City of Portland, Maine - Building or Use Permit Application
 389 Congress Street, 04101 Tel: (207) 874-8703, Fax: (207) 874-8716

Permit No: 04-0852	Issue Date:	CBL: 105 R021001
------------------------------	--------------------	----------------------------

Past Use: Single family residence	Proposed Use: Single family residence w/ new front door & steps to entry	Permit Fee: \$93.00	Cost of Work: \$8,000.00	CEO District: 1
Proposed Project Description: Changing front door and steps to entry on single family home		FIRE DEPT: <input type="checkbox"/> Approved <input type="checkbox"/> Denied	INSPECTION: Use Group: Type	
		Signature:	Signature:	
PEDESTRIAN ACTIVITIES DISTRICT (P.A.D.)				
Action: <input type="checkbox"/> Approved <input type="checkbox"/> Approved w/Condition <input type="checkbox"/> Denied				
		Signature:	Date:

SECTION A

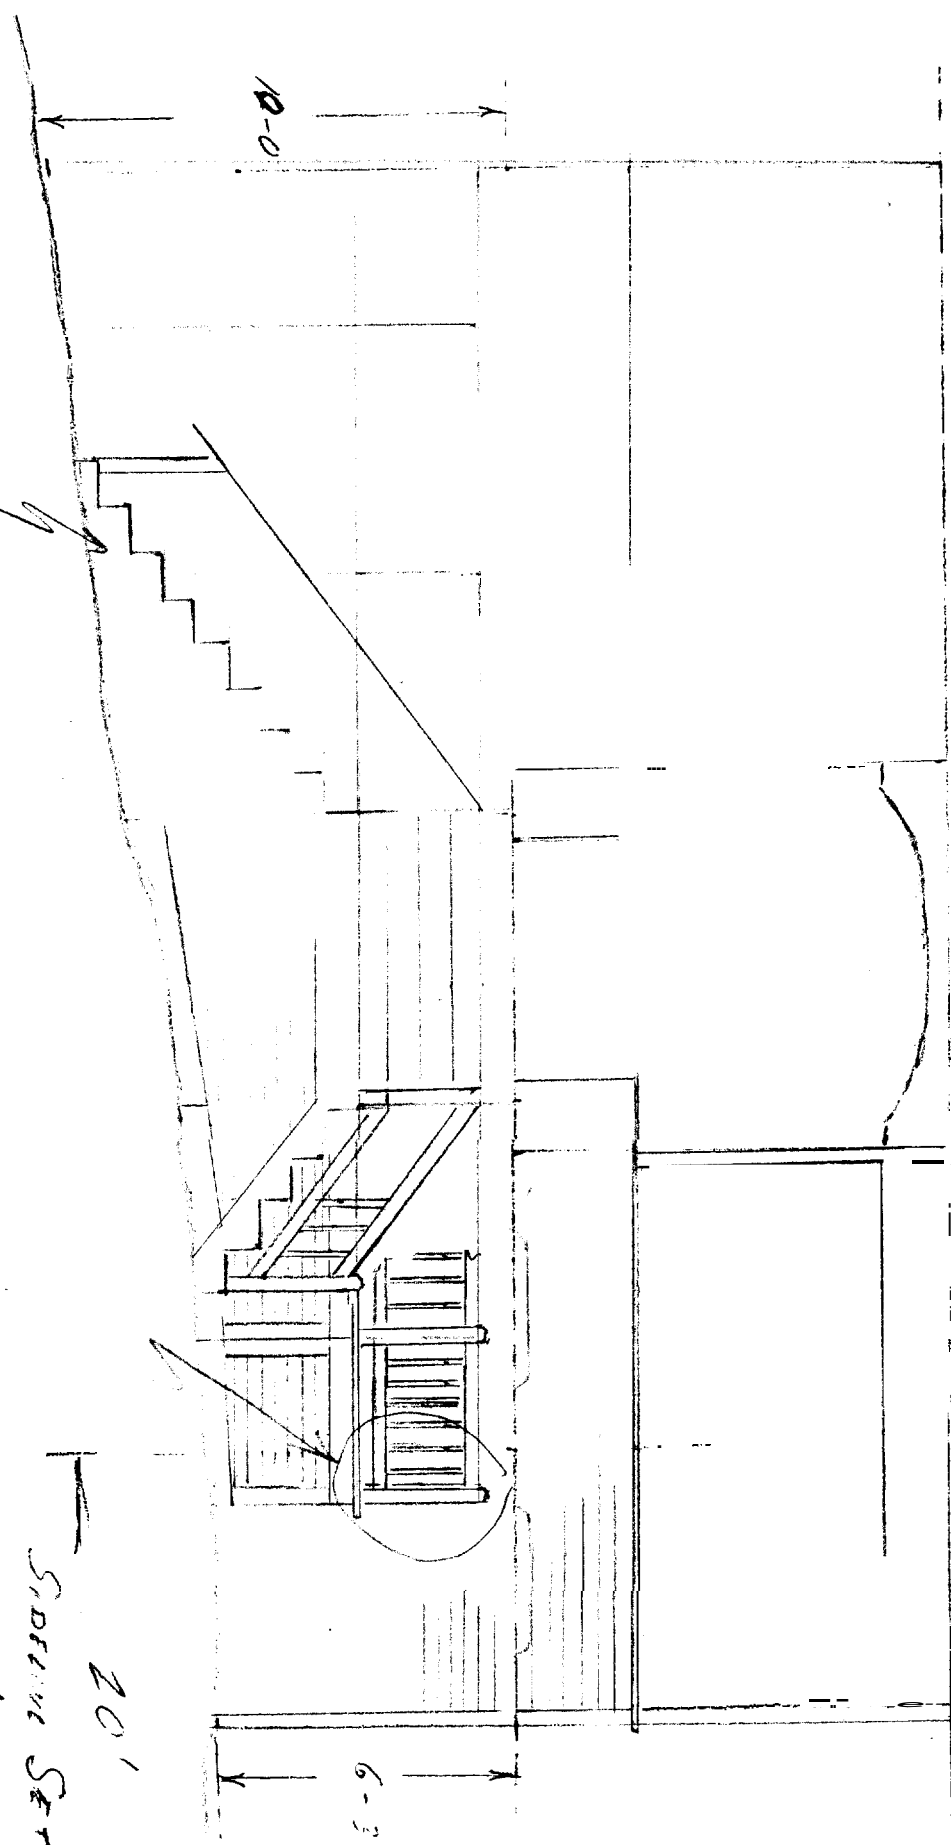
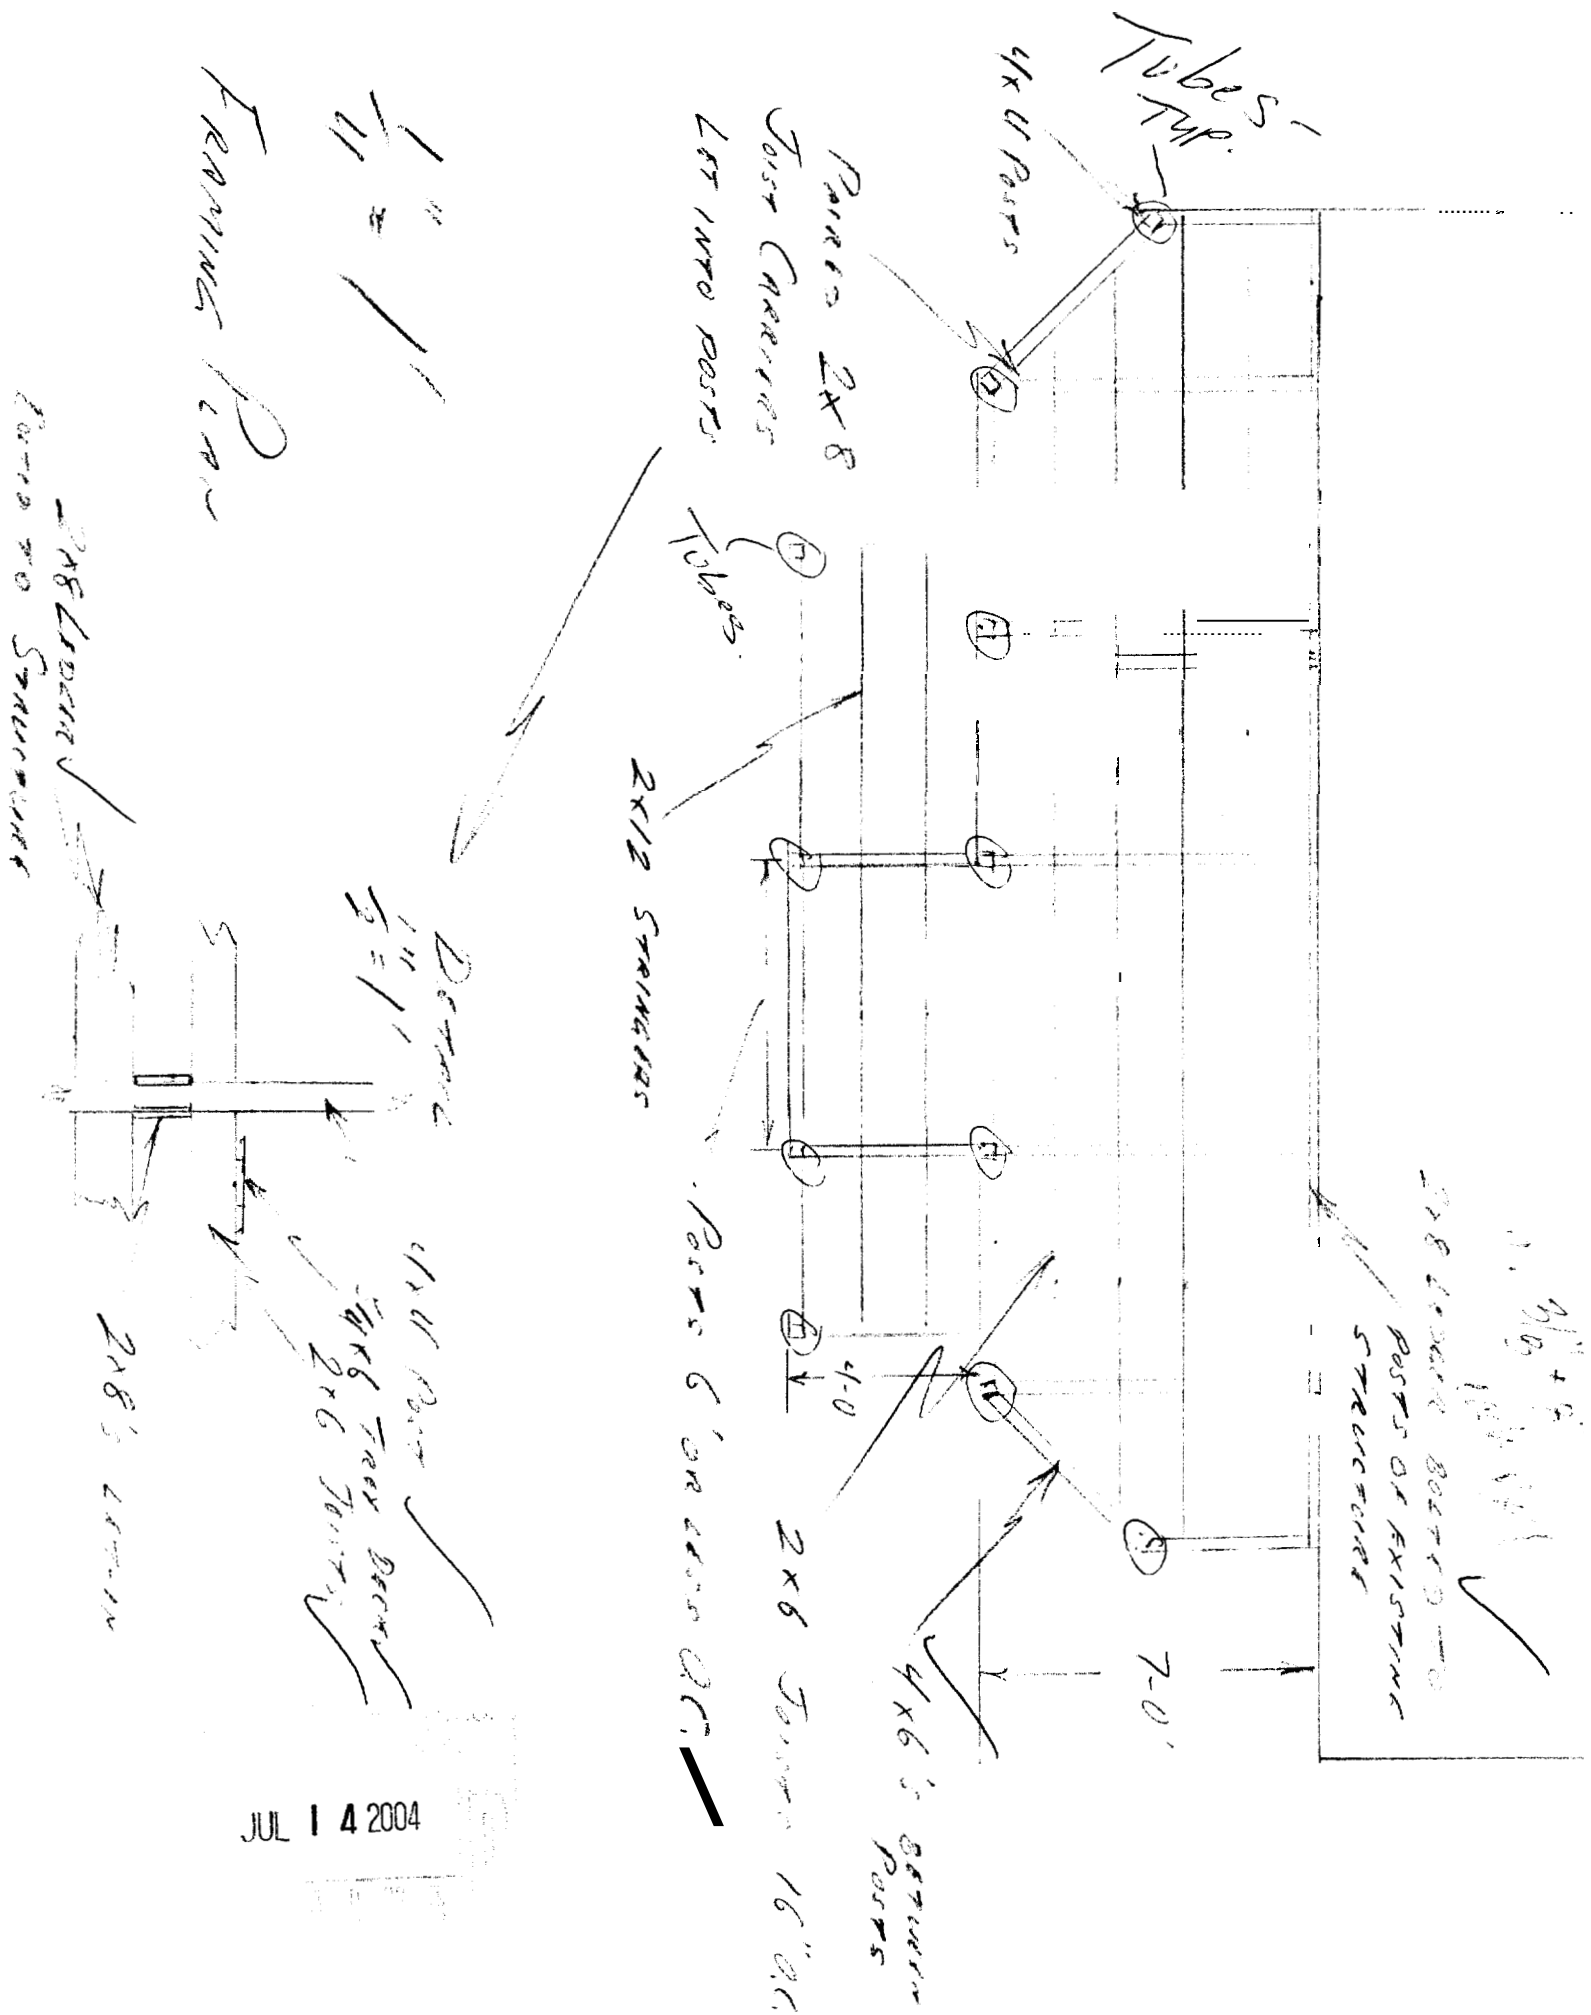
Comments:
7/13/04-tmm: Need to know dimensions of porch, need joist spans, carrying beam, tubes need to be 4' below grade or ledge, guardrail height, plot plan(submitted plan only shows front setback, and balluster spacing shows 6"oc. Called builder and spoke with him. Will submit more info Wed.
